**KIRKLEES METROPOLITAN COUNCIL  
INVESTMENT & REGENERATION SERVICE**

Reference No:	<b>2024/62/90460/E</b>
Site Address:	8, Fair Ways, Upper Hopton, Mirfield, WF14 8PY
Description:	Erection of two storey side extension and single storey infill front extension with associated alterations
Recommending Officer:	Jennifer Booth

**DECISION – Conditional Full Permission**

## **OFFICER REPORT**

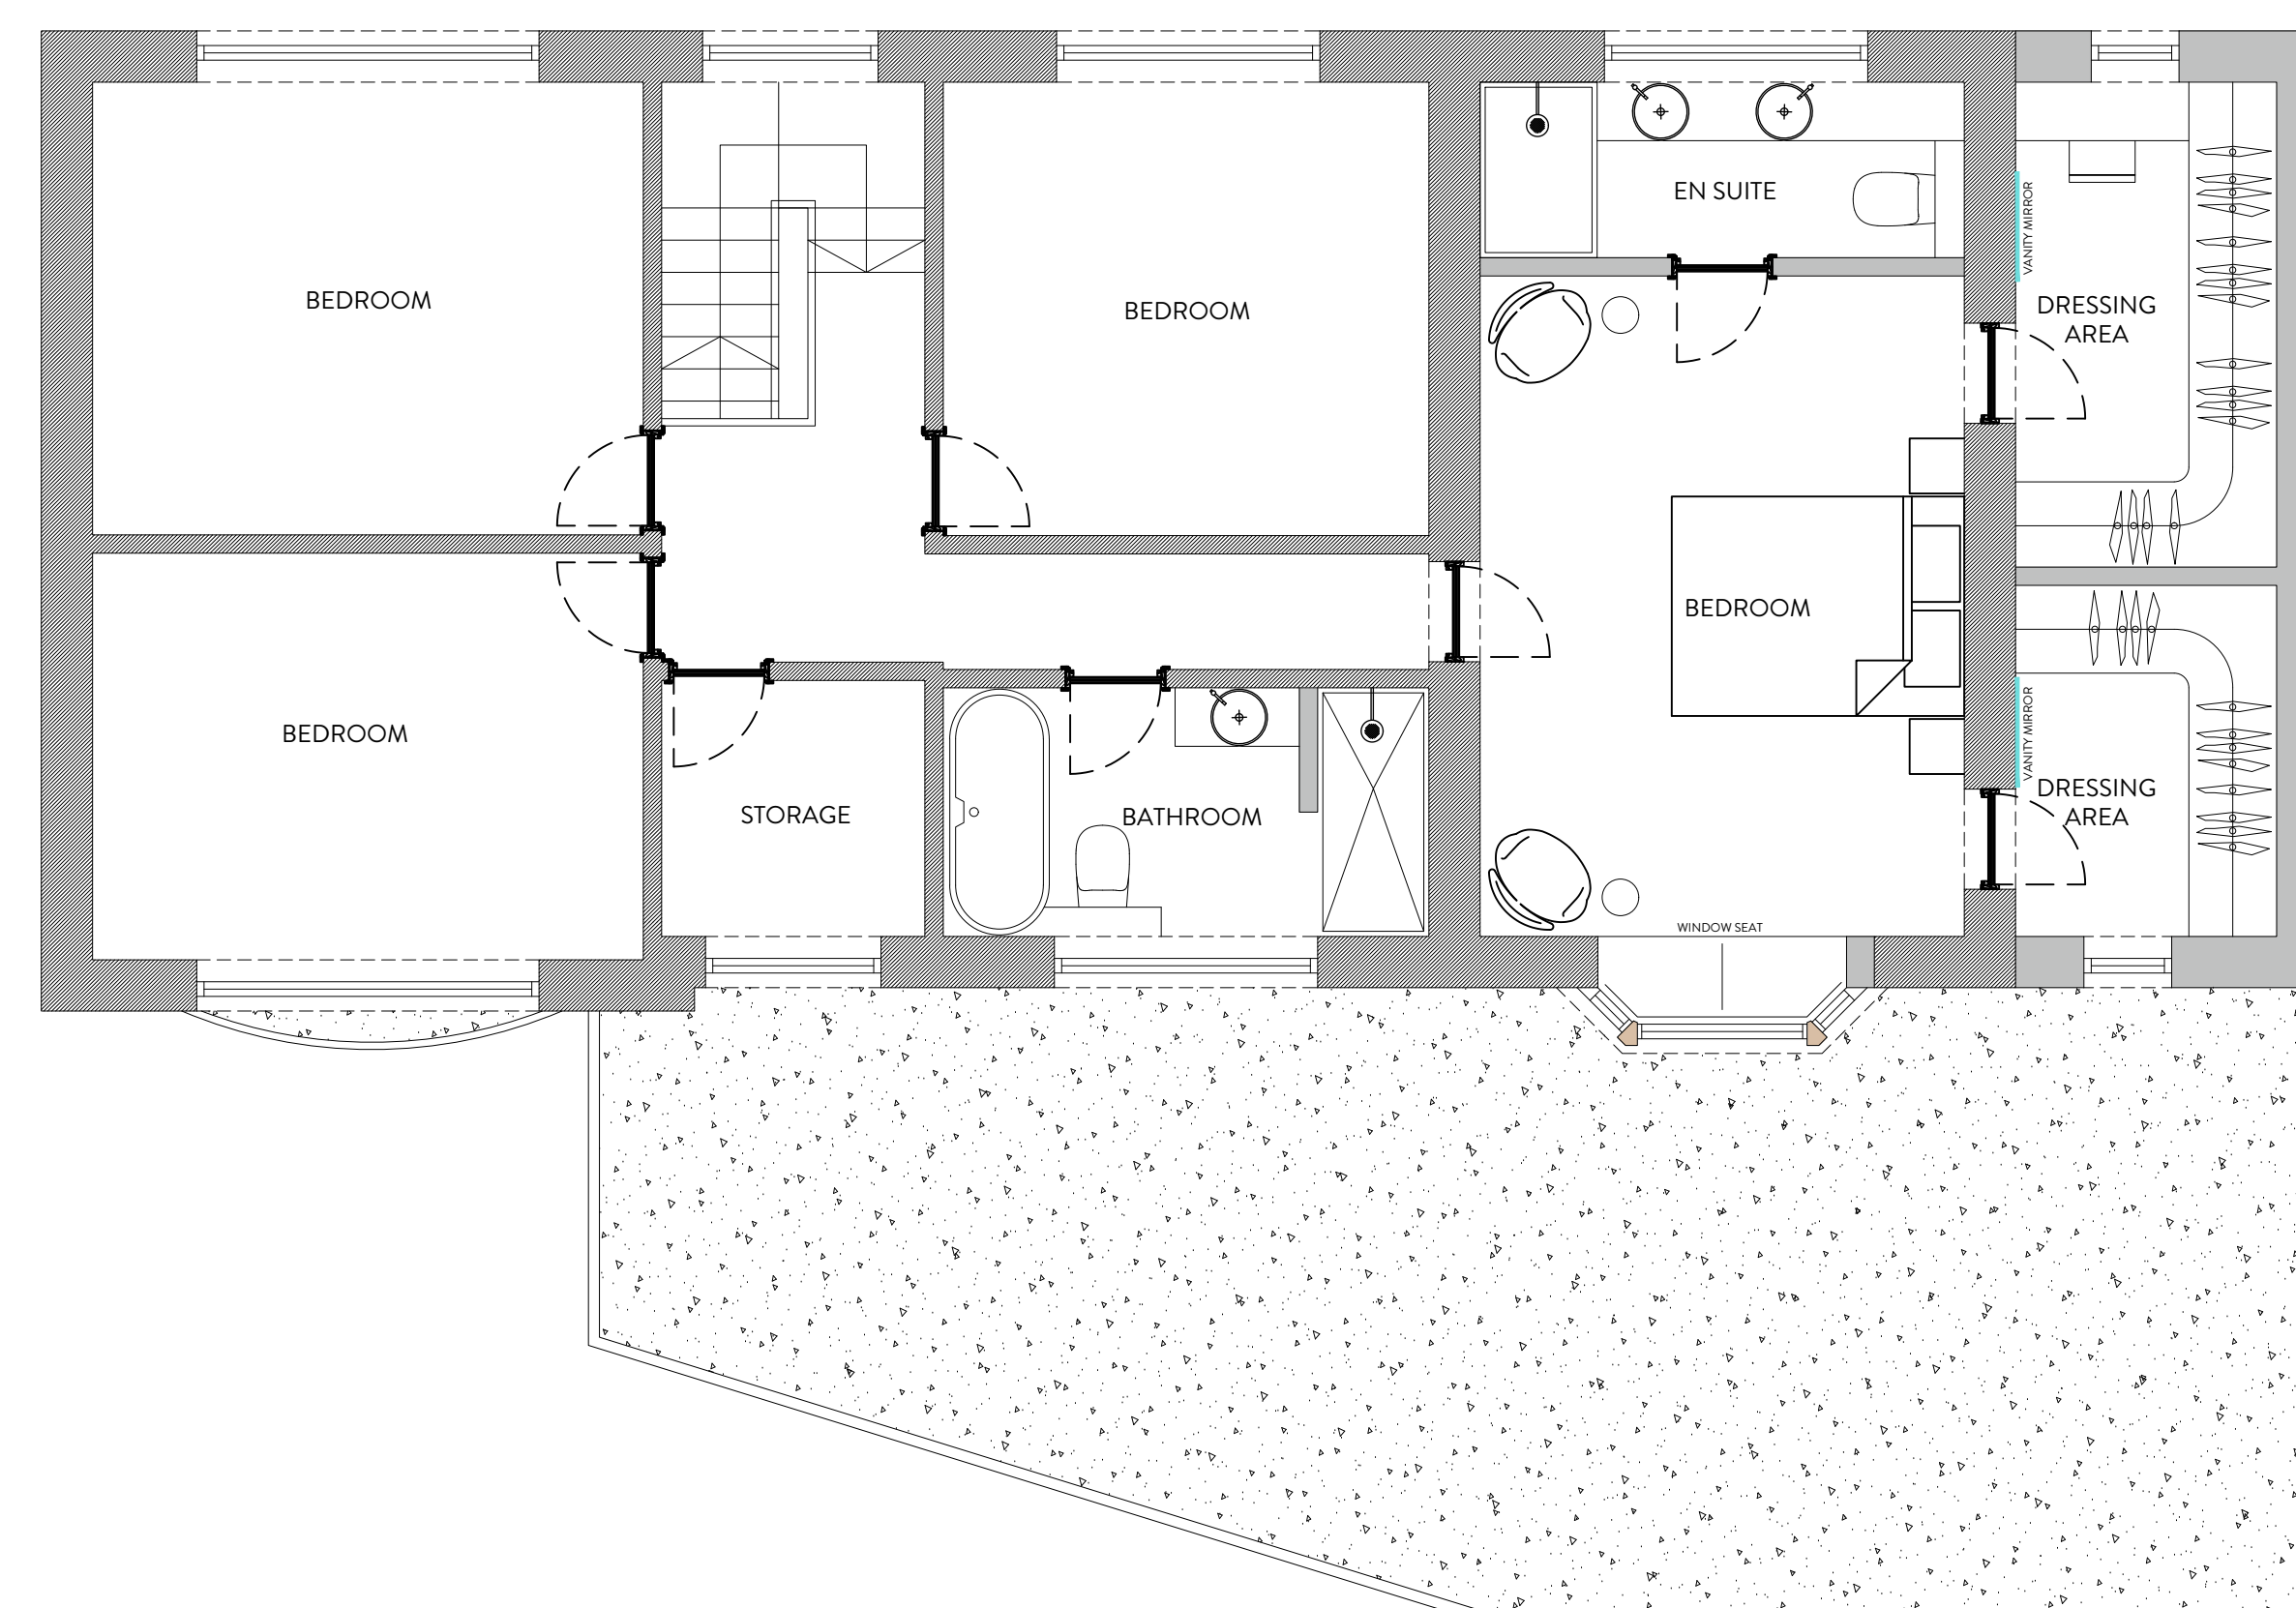
- Impact on neighbours window – **response:** *this is a material consideration in terms of residential amenity. Amended plans have been supplied which alter the roof form over the side extension to a hipped roof form which reduces any impacts on the neighbours window.*

The agent supplied amended plans in response to objection to alter the roof over the side extension. As the alteration reduced the level of development, the amended plans have not been advertised.
